From: Nicola Spencer
Sent: 21 December 2018 09:22
To: Karen Parsons
Subject: FW: 2 Pagham Road, P/99/18/HH

From: Paul Wright [REDACTED]
Sent: 12 December 2018 19:57
To: Stuart Corbey
Subject: 2 Pagham Road, P/99/18/HH

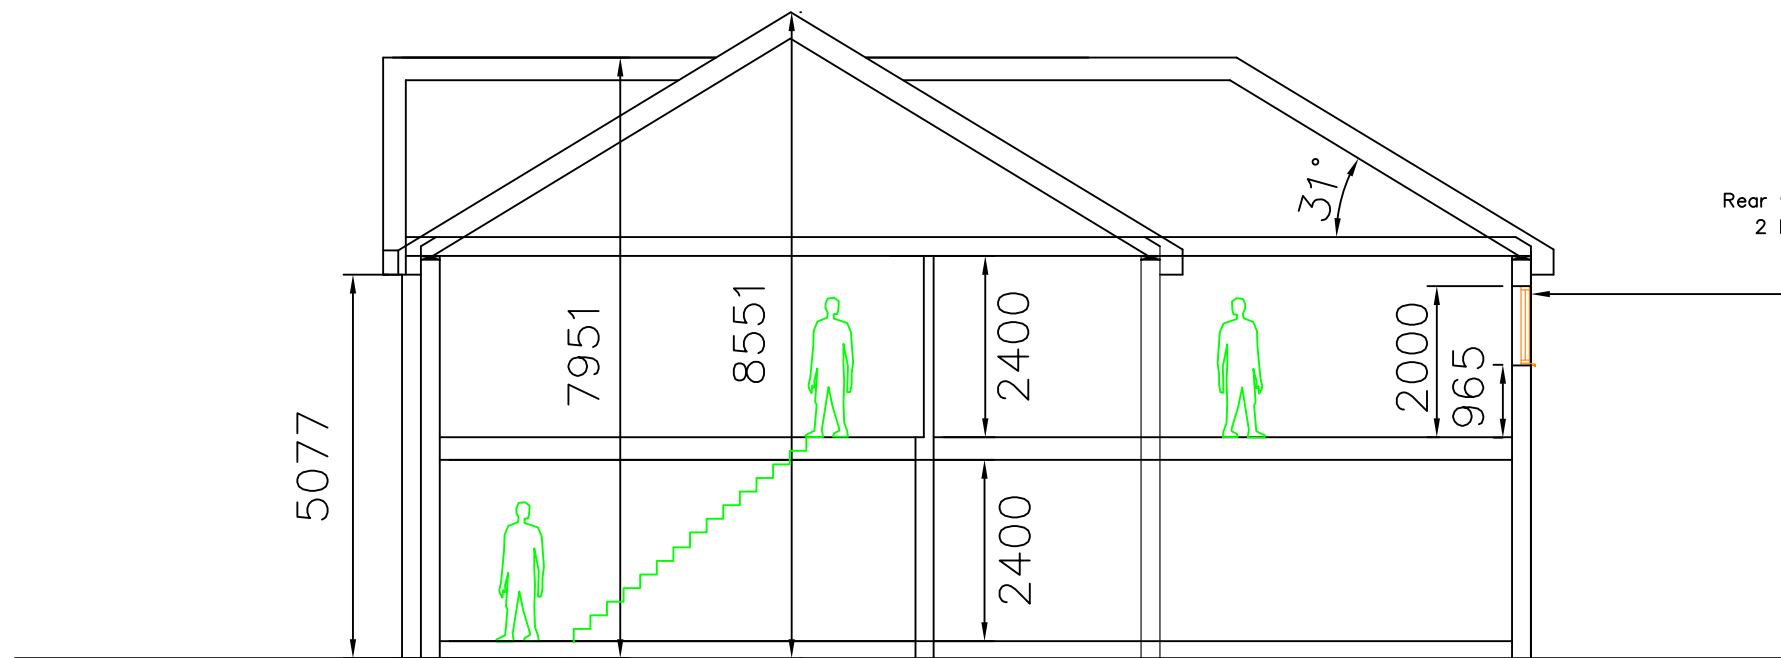
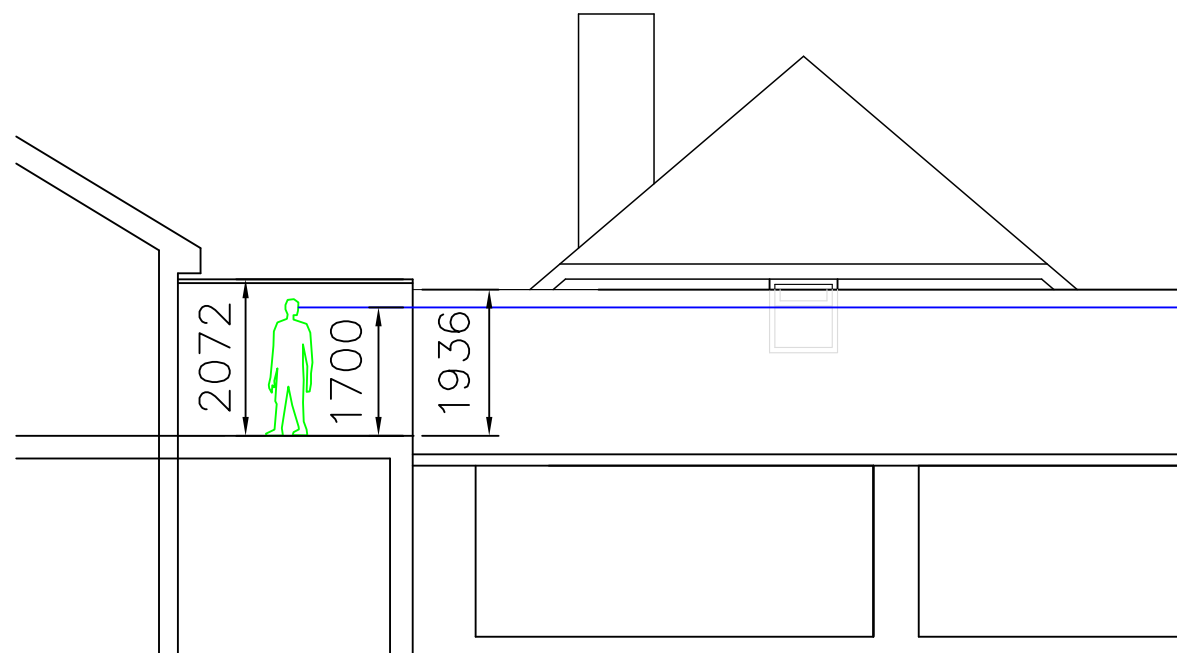
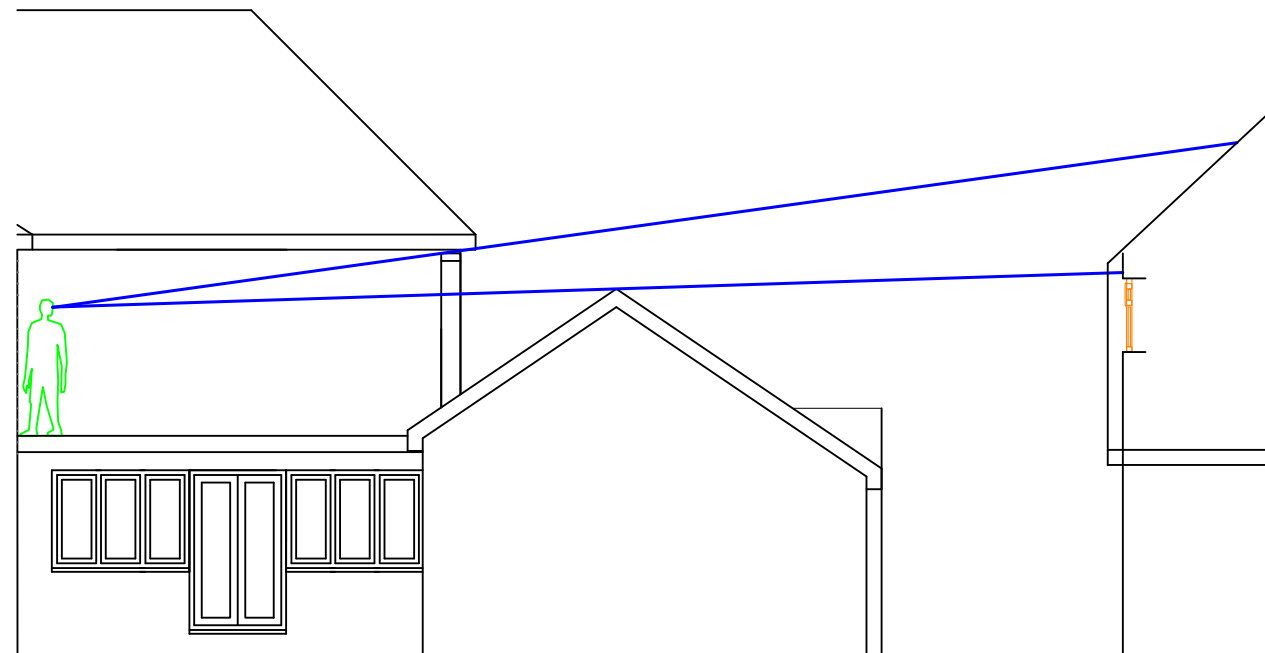
What would be helpful is a cross section and elevation of the proposed development inclusive of the site arrangement with the existing outbuilding (dotted line) in addition to extant permission under P/18/03. This level of plan would make the situation more clear and assist with the assessment.

I am not sure what more detail I can provide to the cross-section P006_B so please could you give me a call to explain what exactly you require, and I will get this done immediately. I have left you a voicemail also this morning.
